OAKLANDS FARM SOLAR PARK

Non-Material Change Supporting Statement (EIA Addendum)

Document Ref: EN010122/NMC/1.1

Planning Inspectorate Reference	EN010122
Document Reference	EN010122/NMC/6.1
Author	Oaklands Farm Solar Limited

TRACK CONSTRUCTION DETAIL

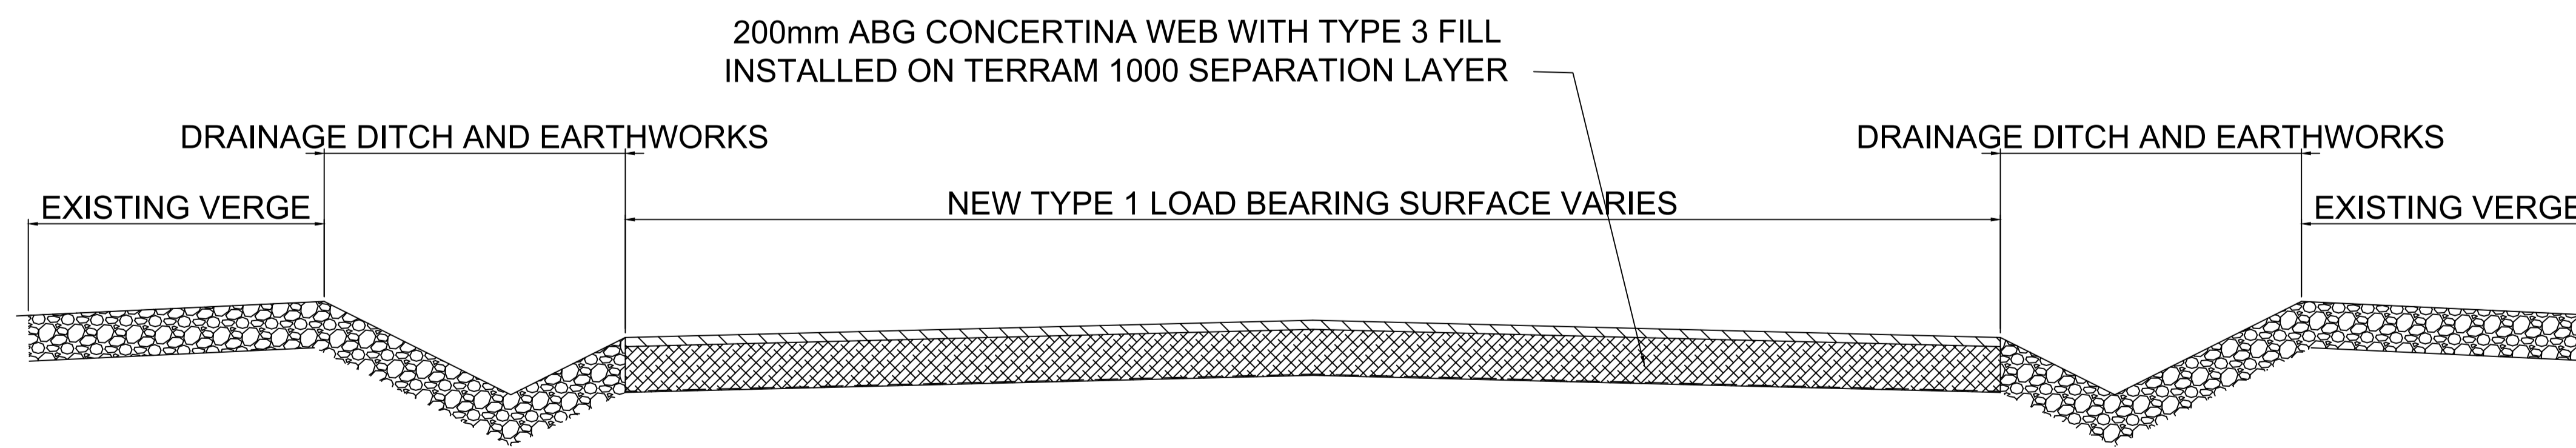
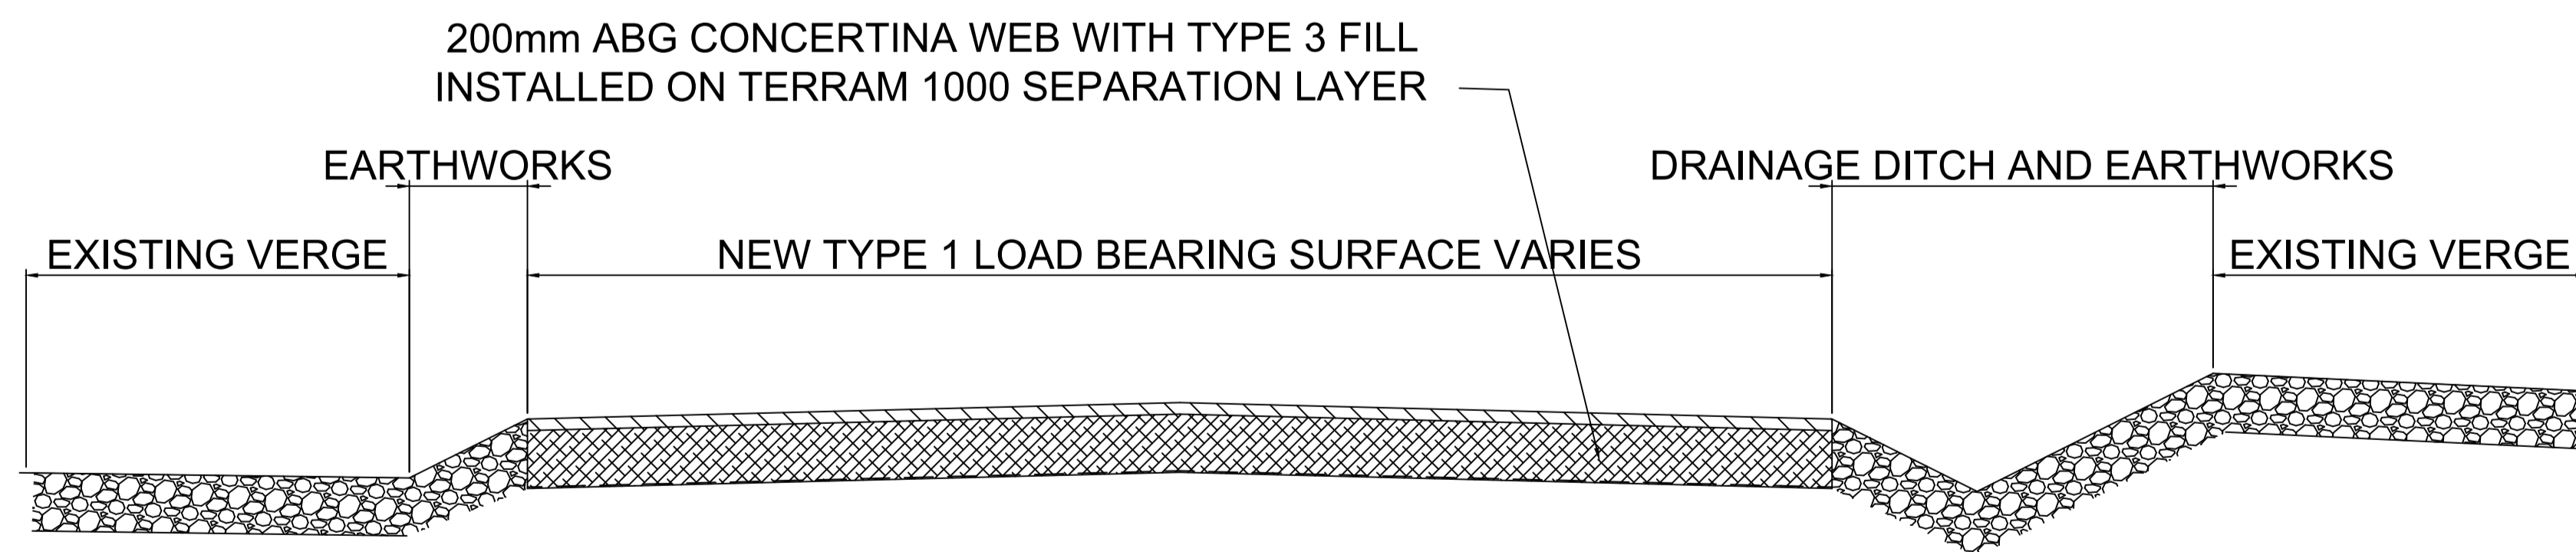
- 3.8.1 Currently the parameters allow for a permanent access track of 3.5 – 6.0m wide made up of 200mm of type 1 compacted stone/gravel with a geotextile membrane, or mown grass corridor. It is now proposed that this is amended to allow up to 400mm of compacted stone/gravel, such as type 1/6F5, with a geotextile membrane, or mown grass corridor.
- 3.8.2 It should be noted that the additional 200mm of the material would be used to build up the road as opposed to requiring further excavation.

EN010122 - D5 - 13.7 - Indicative Cable
Trench Plan

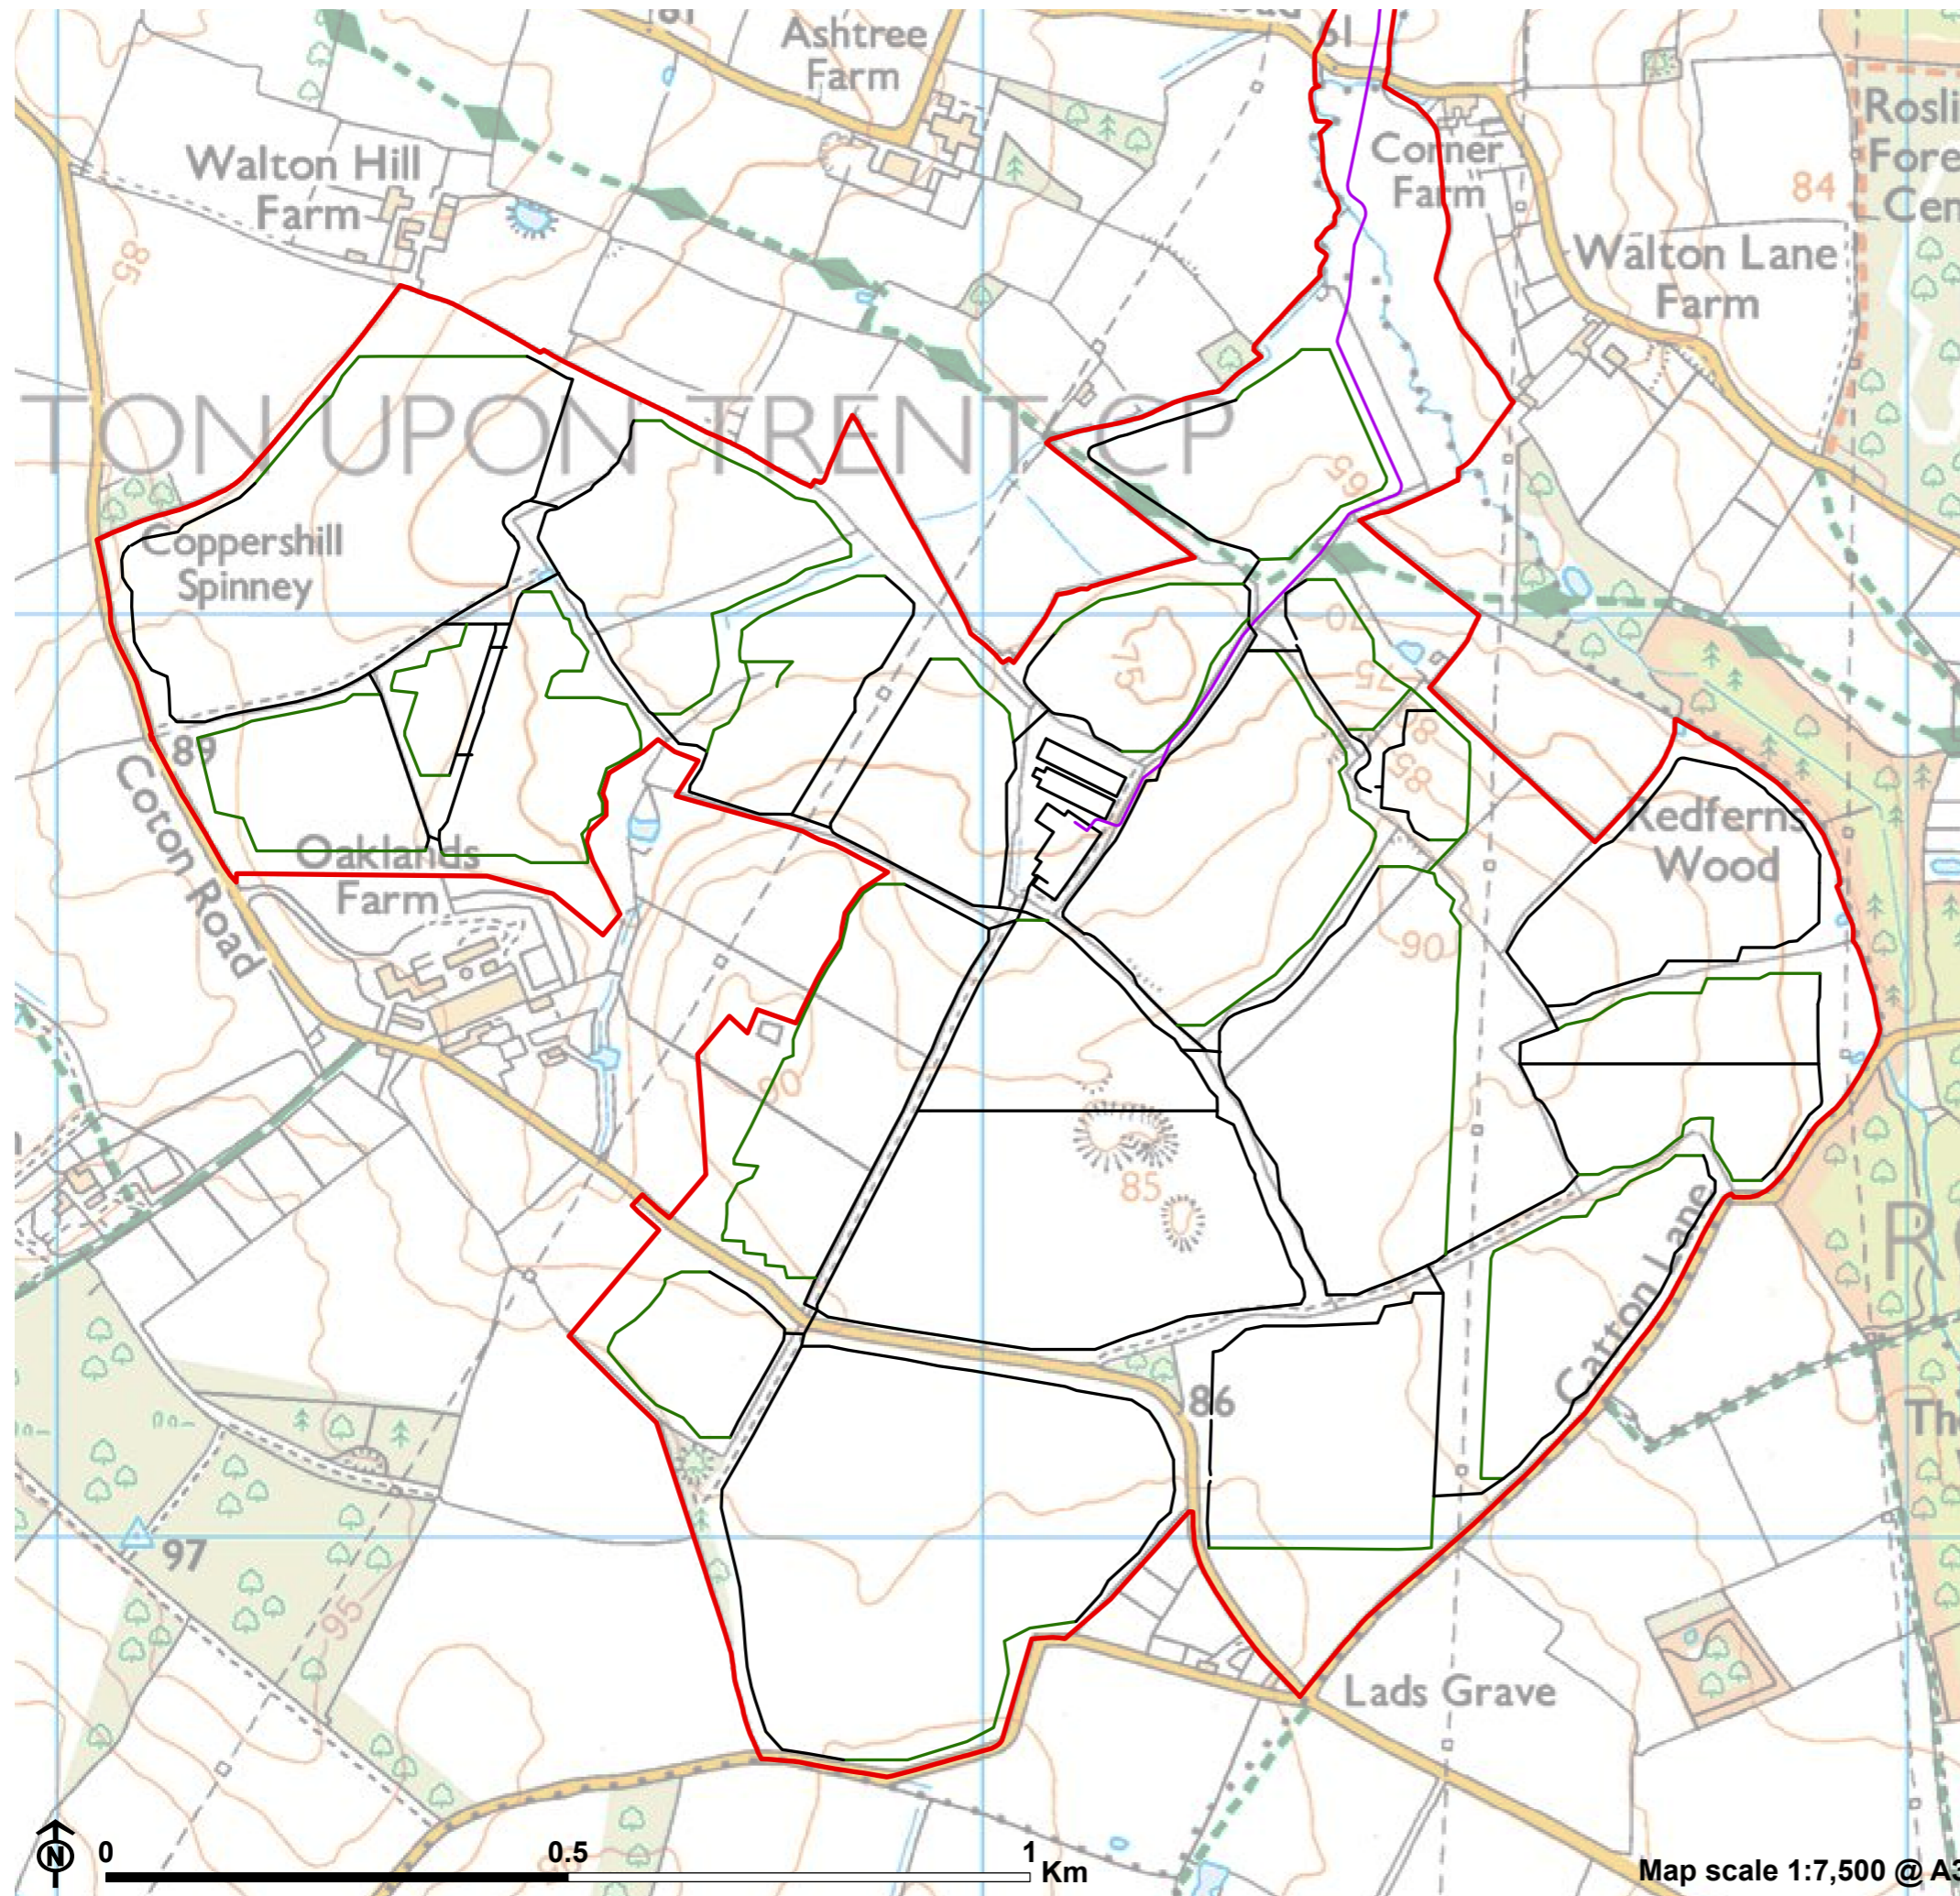
- 3.7.2 The parameters allowed for a minimum cable depth of 0.9m and a maximum cable trench dimension of 1.5m wide and 1.2m deep. Following detailed design work including investigations of ground conditions and characteristics such as soil resistivity, it is now proposed that the minimum buried cable depth would be 0.7m below ground level and the maximum cable trench dimensions would be 1.8m wide and 1.2m deep, apart from in exceptional circumstances to cross features such as other cables, where the trench depth will be specific to engineering requirements.
